Charlotte Storm Water
600 East Fourth Street
Charlotte, N C 28202-2844

Rezoning Petition Review

Rezoning Petition #: 20-86

Location of Property: Approximately 71.94 acres located on the south side of University City Blvd, west of I-485 and north of Mineral Springs Rd.

RZ-3.1

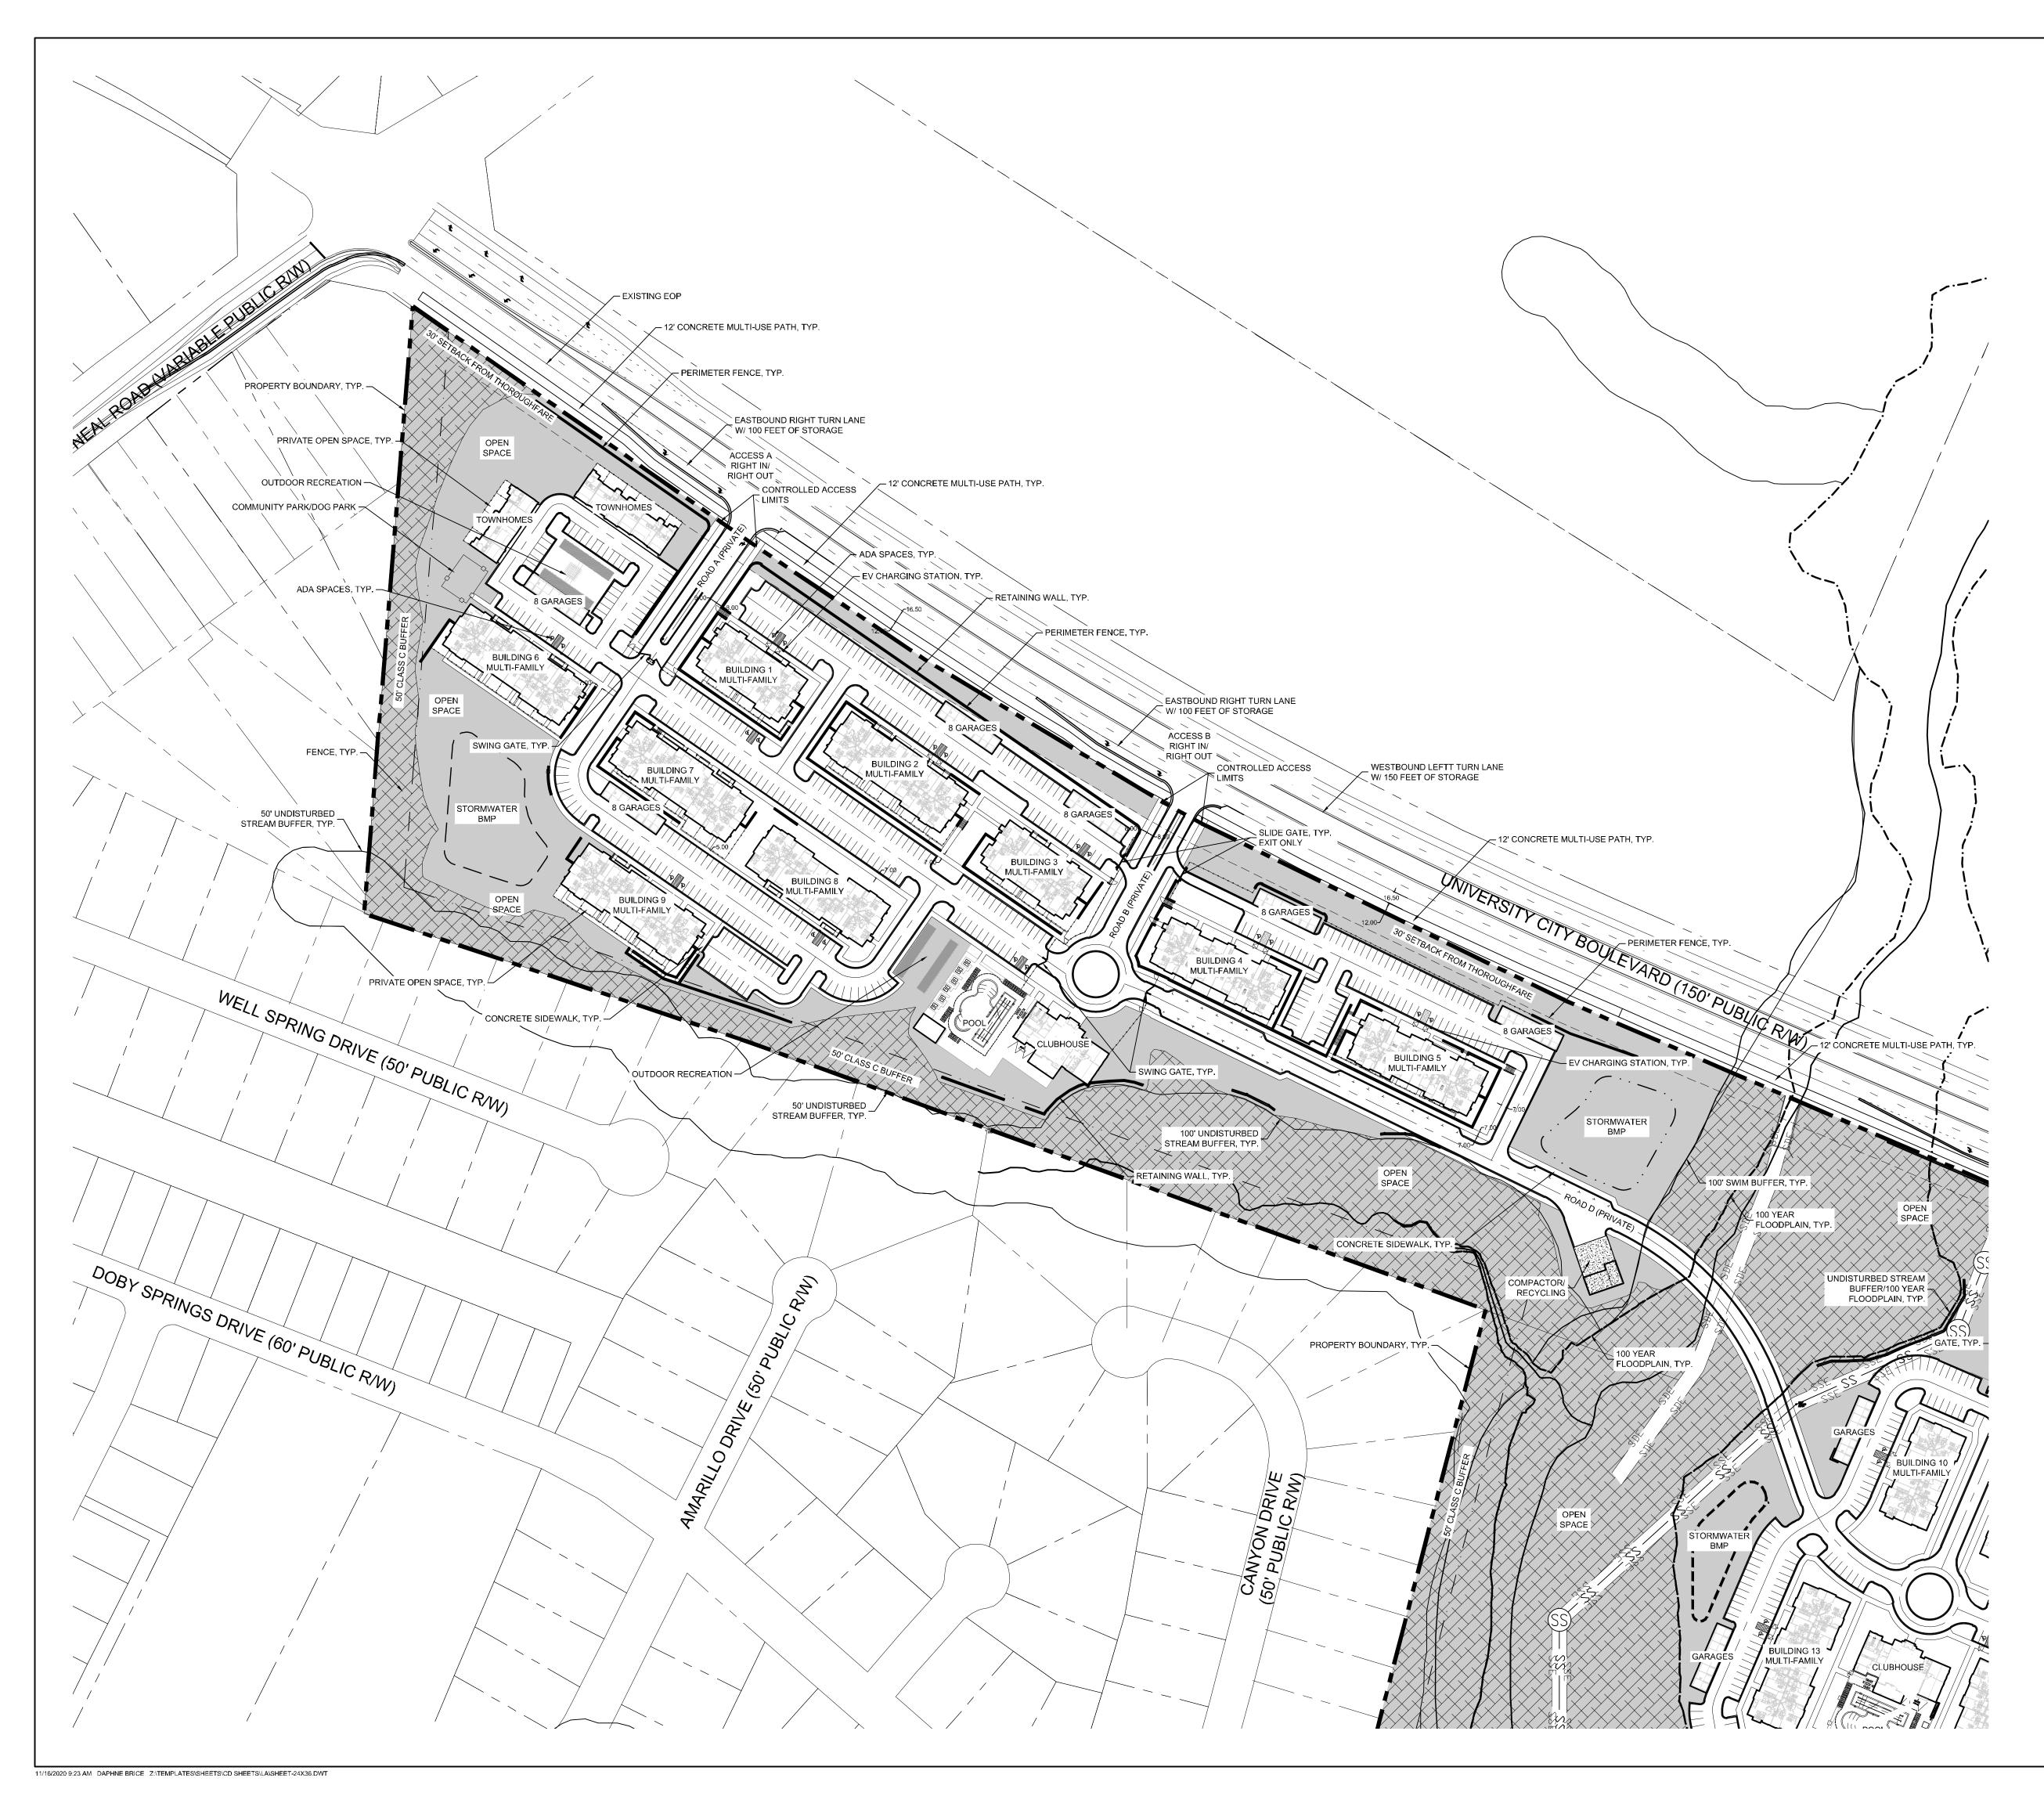
For adjoining parcels receiving storm water discharge, specifically the residential communities identified for the development portion on sheet RZ-3.1, the petitioner shall analyze the adequacy of the existing storm water conveyance on the adjoining parcels to the FEMA confluence. If the existing storm water conveyance on the adjoining parcels is found to be inadequate, the Petitioner shall make a good faith effort with the property owner(s) to improve the storm water conveyance or mitigate the storm water discharge onto

the adjoining parcels.
